Erection of 8 dwellings with garaging & open resident & visitor parking, with a new access from Arundel Road; provision of hard & soft landscaping & open space; foul & surface water drainage systems; & other works - This application is a Departure from the Development Plan

Land South of Arundel Road Walberton

Thank you for your internet representation made on 12th August 2019 which has been recorded as '**an objection**' with the comments as follows:

PLOT 1&2 - PLANS & ELEVATIONS

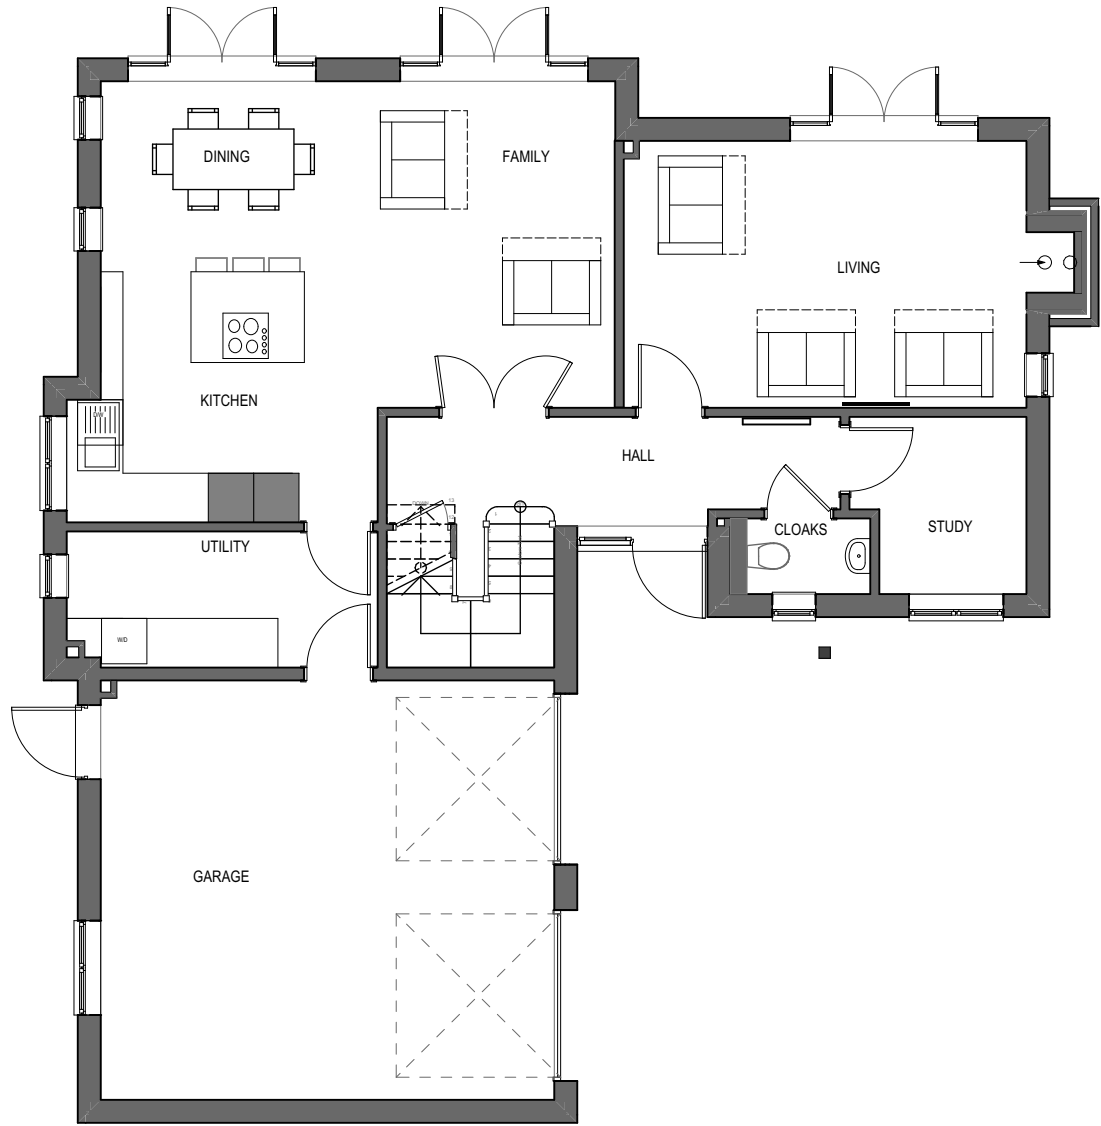
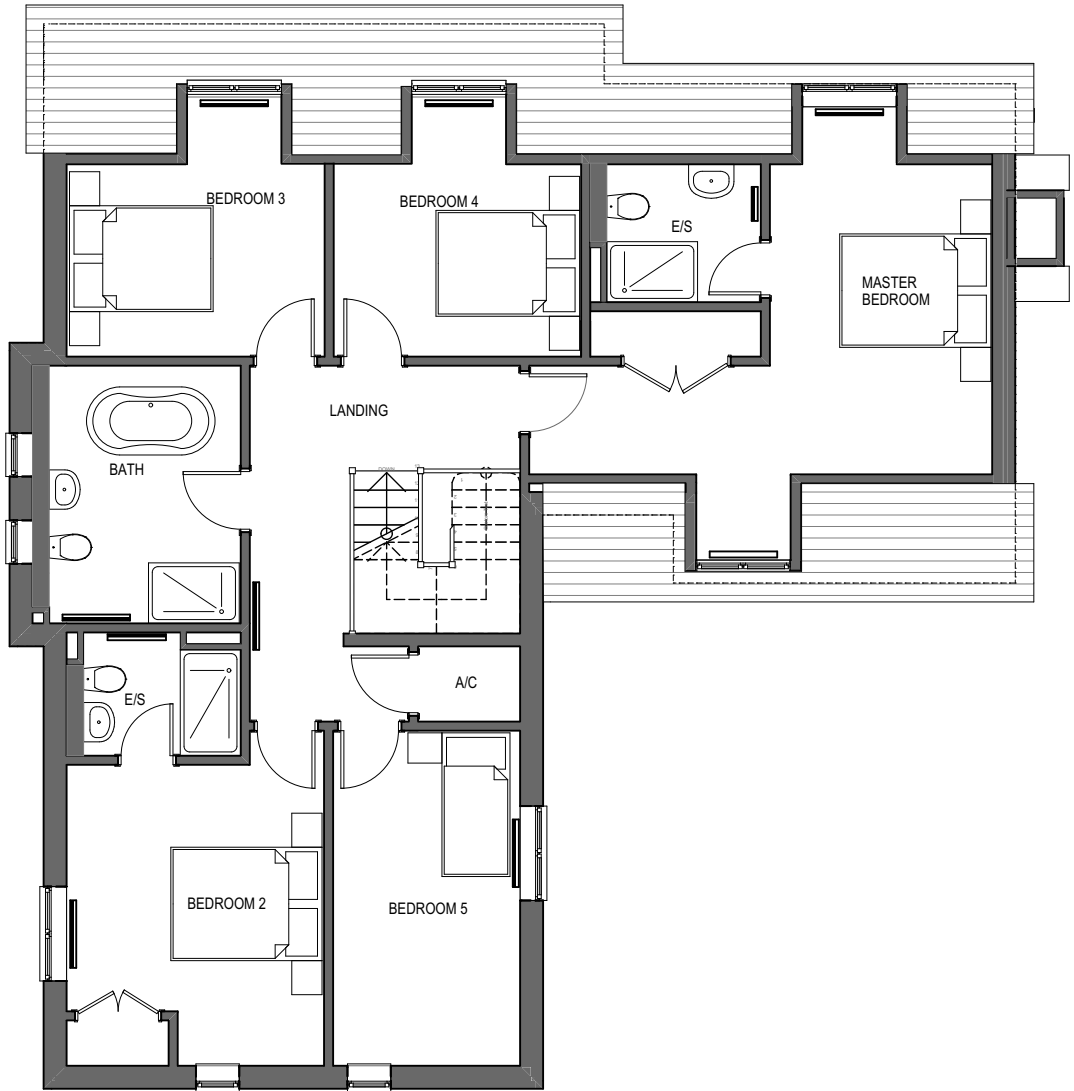
Taking into account the available space on the site we have concerns that the proposed 'Gateway' style entrance will result in plot 1 overlooking the neighbouring property - Foxwood cottage. This will result in loss of privacy for both properties. We understand that our neighbour has submitted an alternative proposal to overcome this issue which we would support.
